21 February 2020

Case Number EQ/20/50092
Proposal Agricultural dwelling
Site Wicksmead, Penn Common Road, Bramshaw, Lyndhurst,
SO43 7JL

Project Title: WICKSMEAD, PENN COMMON BRAMSHAW. SO43 7JL		
Drawing Title: FLOOR PLANS		
Client: MR & MRS PARKS		
Scale: 1:100 @ A3	Date: SEPT 20	Drawn by: OE
Job No: W200 269	Drawing No: SK01	Rev: J

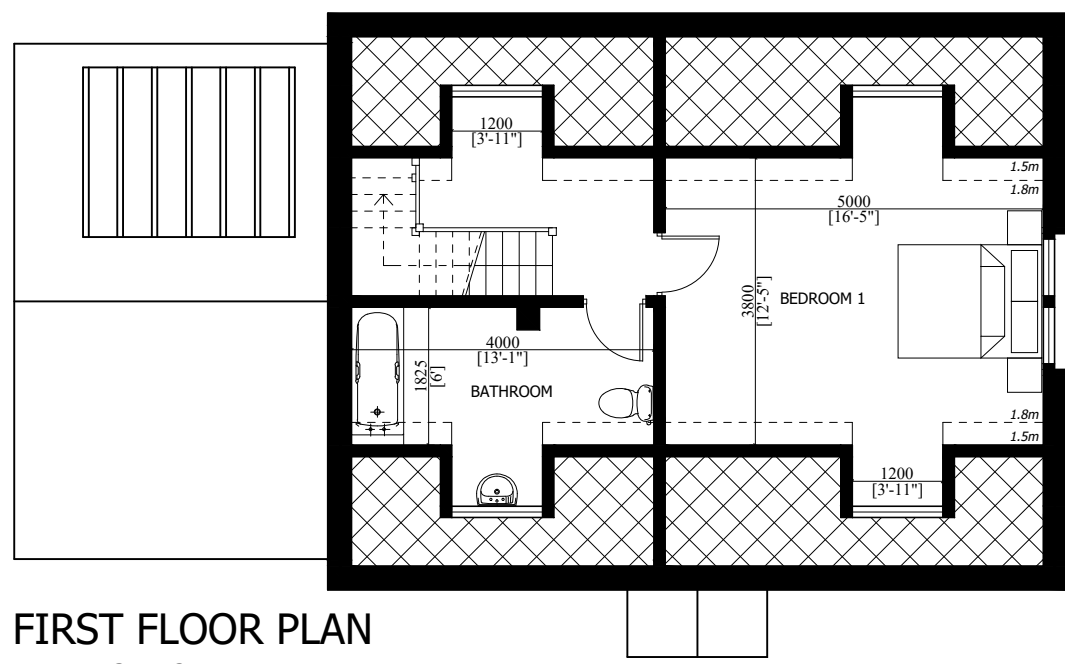
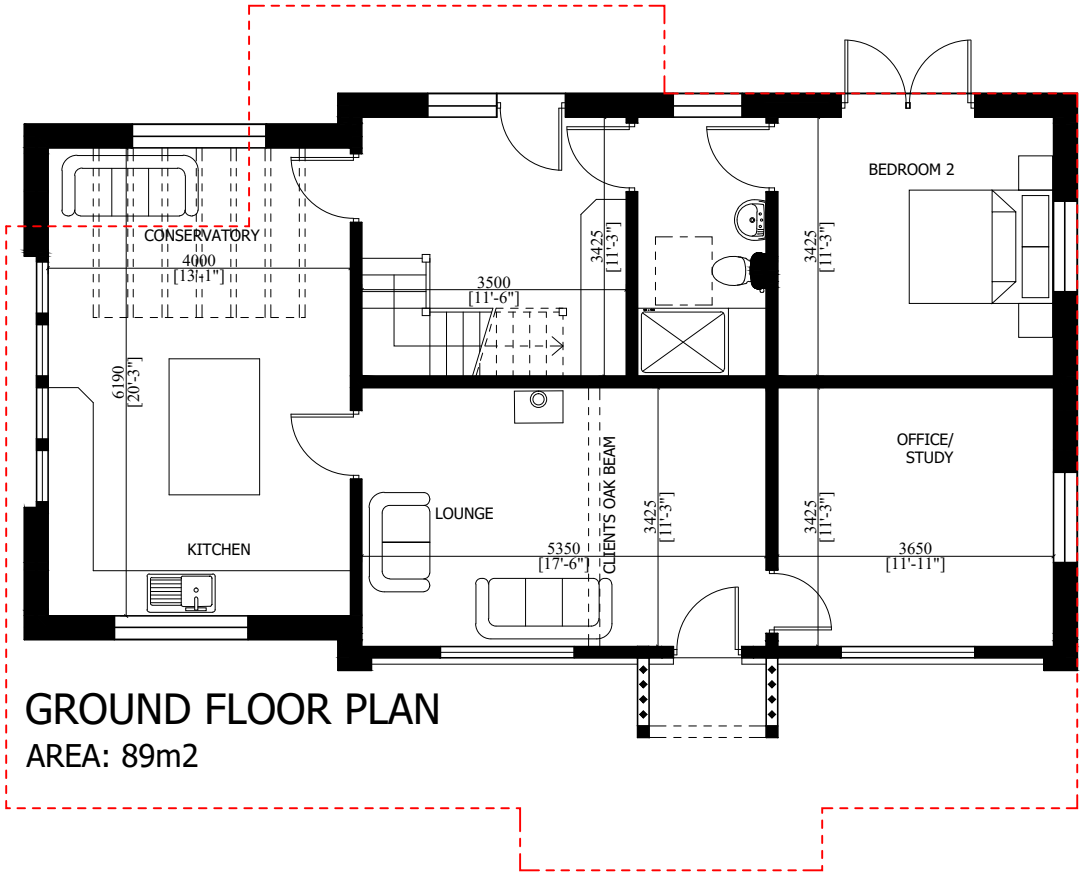
The intentions of your proposal would be for it to be no larger than what is currently in situ. In principle this would be acceptable. It should be noted that any area of the attic which would have a height of 1.5 metres or above would be included in the floorspace calculations.

Project Title: WICKSMEAD, PENN COMMON BRAMSHAW. SO43 7JL		
Drawing Title: ELEVATION		
Client: MR & MRS PARKS		
Scale: 1:100 @ A3	Date: SEPT 20	Drawn by: OE
Job No: W200 269	Drawing No: SK02	Rev: H

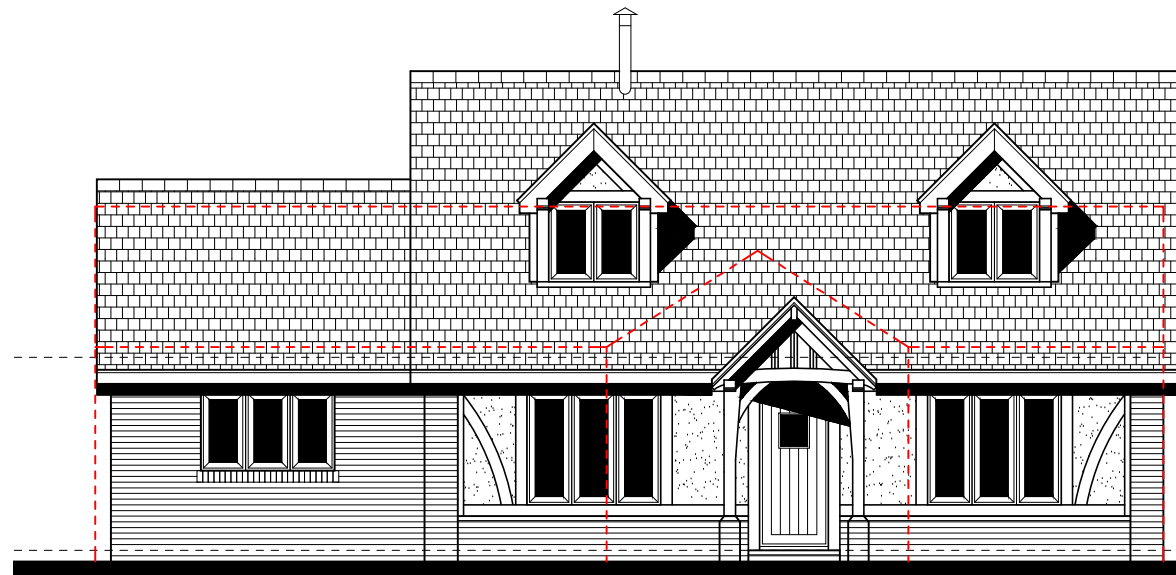
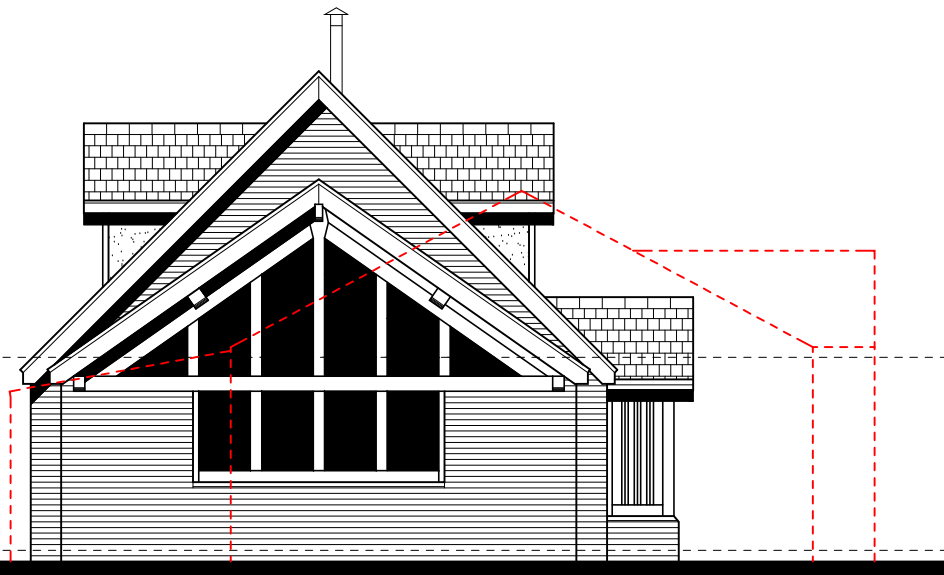
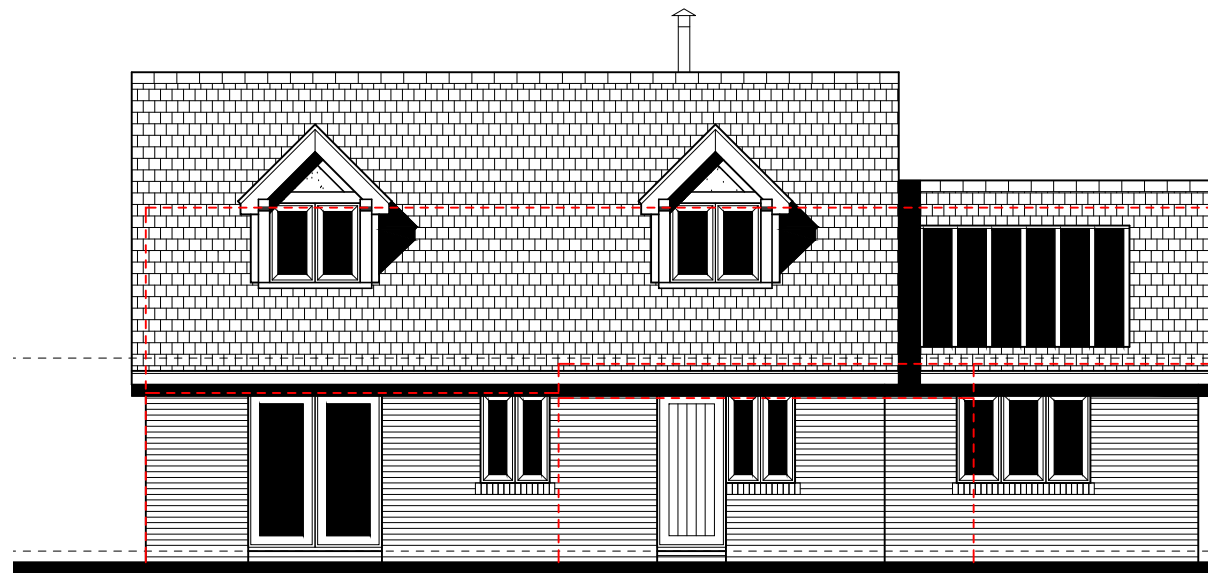
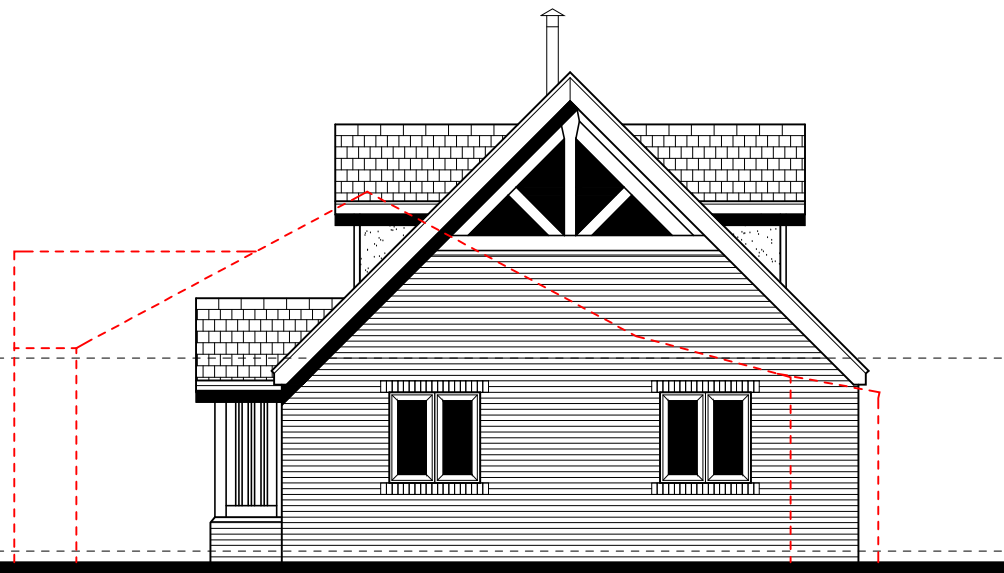
It would be important that the proposed replacement dwelling would be rural in character, nature and materials and have no significant impact on the neighbouring property or SSSI. The dwelling would be clearly visible from the open forest and SSSI and this would need to be sympathetically designed. The gable end triangular windows would appear to be an odd feature.
